Application Ref:	2026/0387			 Ribble Valley Borough Council www.ribblevalley.gov.uk
Date Inspected:	04/08/2026	Site Notice:	N/A	
Officer:	EP			
DELEGATED ITEM FILE REPORT:				APPROVAL

Development Description:	Proposed conversion of garage to office room.
Site Address/Location:	66 Hawthorn Road Barrow BB7 9EE.

DRAWING TITLE
EXISTING SITE / BLOCK PLAN

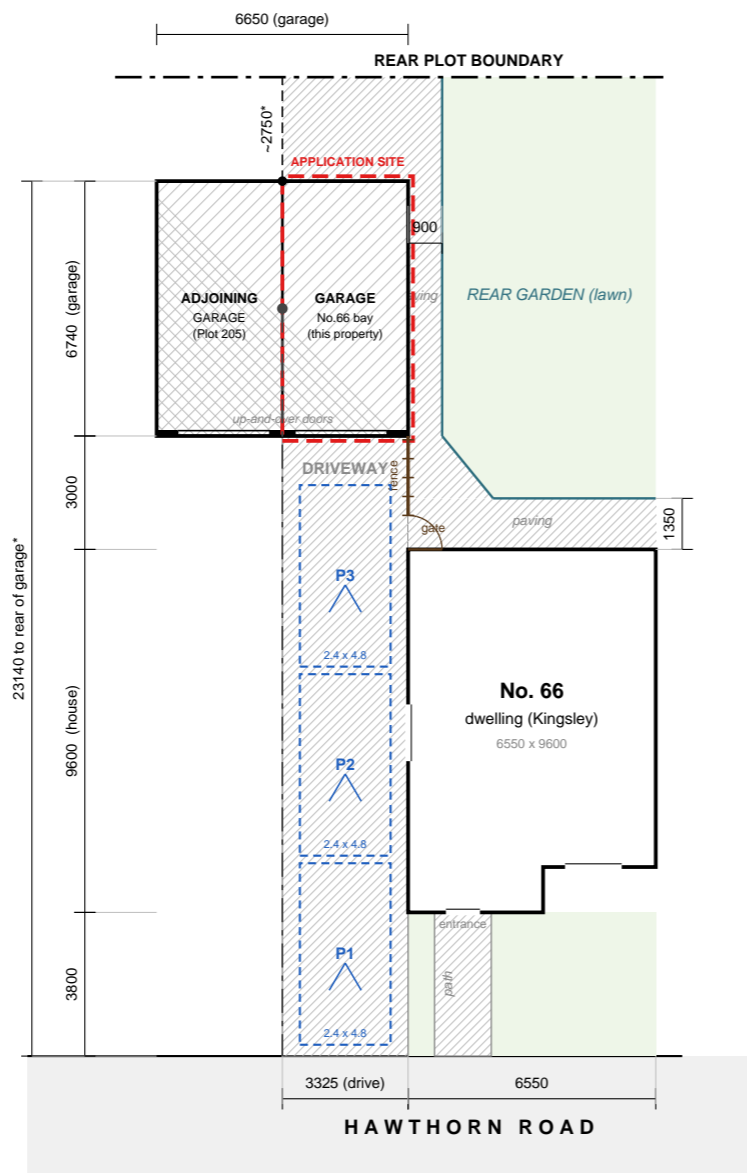
The Local Highways Authority have raised no objection to the proposal. Sufficient parking remains available (3 spaces) on the existing driveway.

It is recognised that concerns have been raised in respect to parking implications and highway safety. However, the application dwelling will not fall short of the required parking spaces by converting the existing garage. 3 spaces for a 4-bedroom property complies with parking standards.

DRAWING TITLE
PROPOSED GARAGE – PLAN & ELEVATIONS

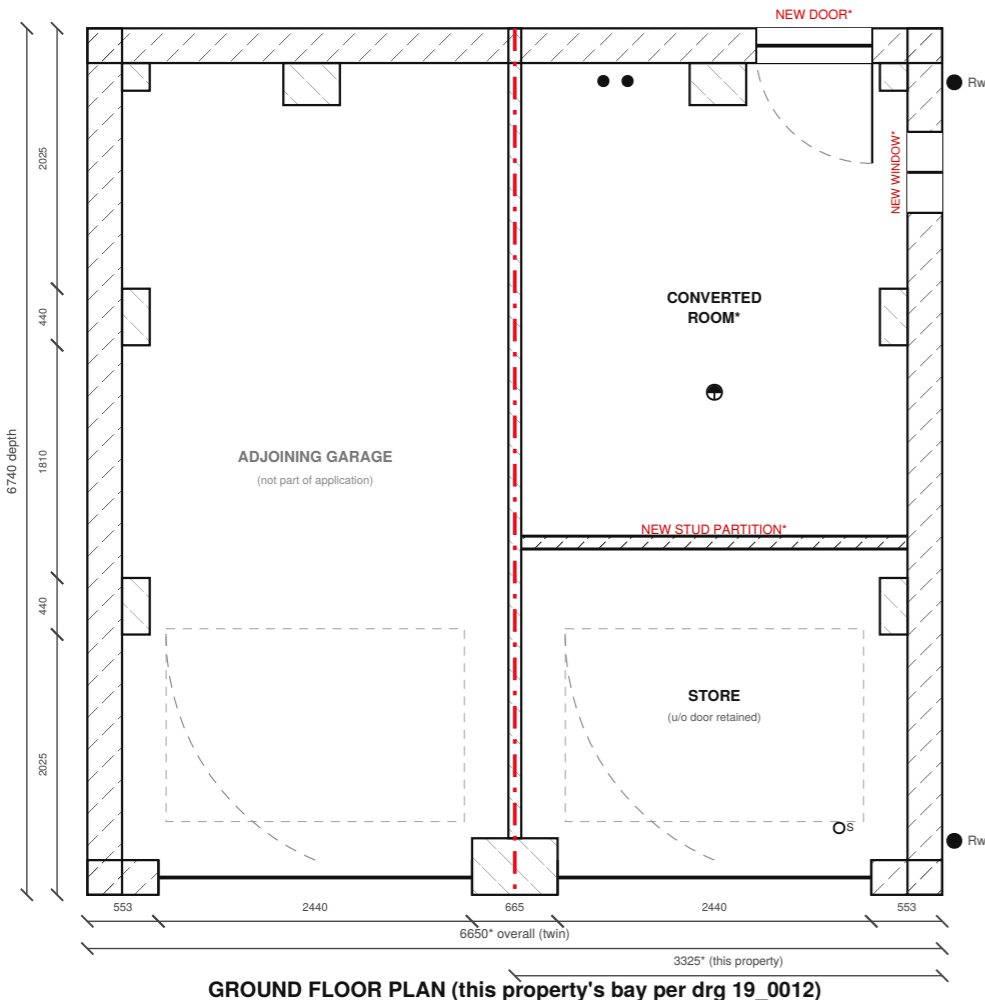
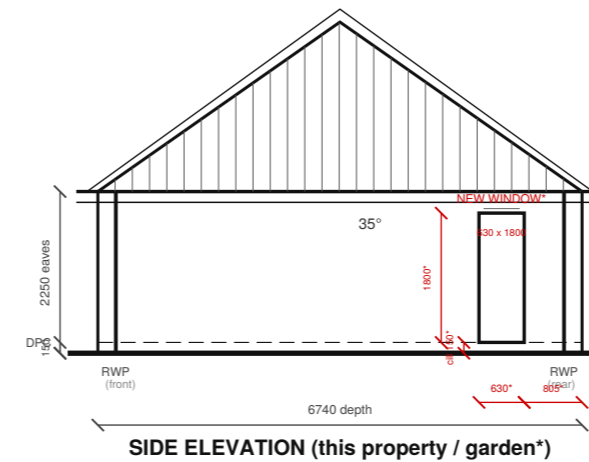
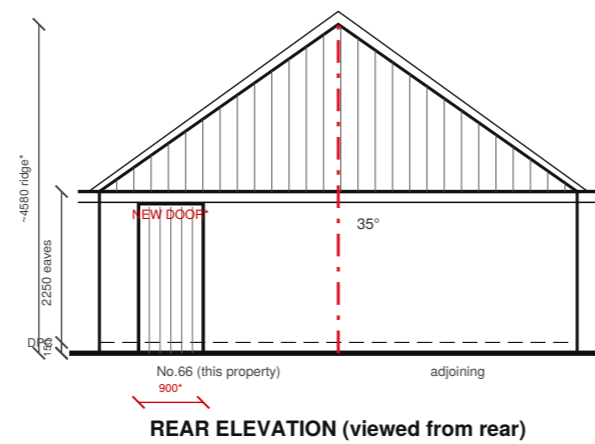
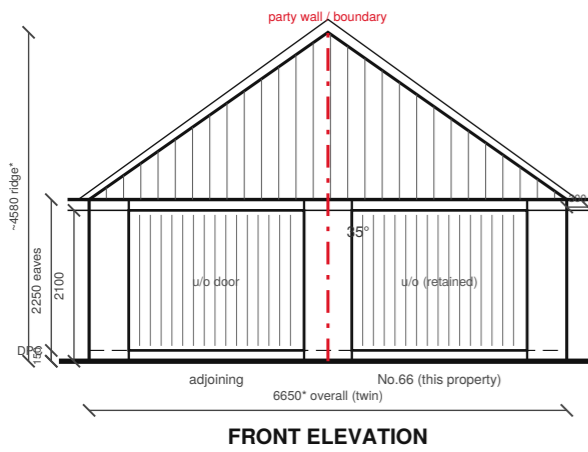
The submitted details seek consent for the partial conversion of an existing garage to become extended living floorspace. With the only external alterations proposed being minor works to the rear and side elevations of the garage. There is a window opening proposed in the side elevation facing the application garden, with an access door proposed in the rear elevation.

Taking account of the proposed works, it is not considered that the proposed openings, by virtue of their configuration and orientation, will result in the diminishing of the sense of privacy. Nor is it considered that proposal will result in any other measurable impacts upon nearby affected residential amenity.

The submitted details do not propose any external alterations to the property or garage that are visible from within the public realm. The existing garage door will remain in situ to accommodate a storage space.
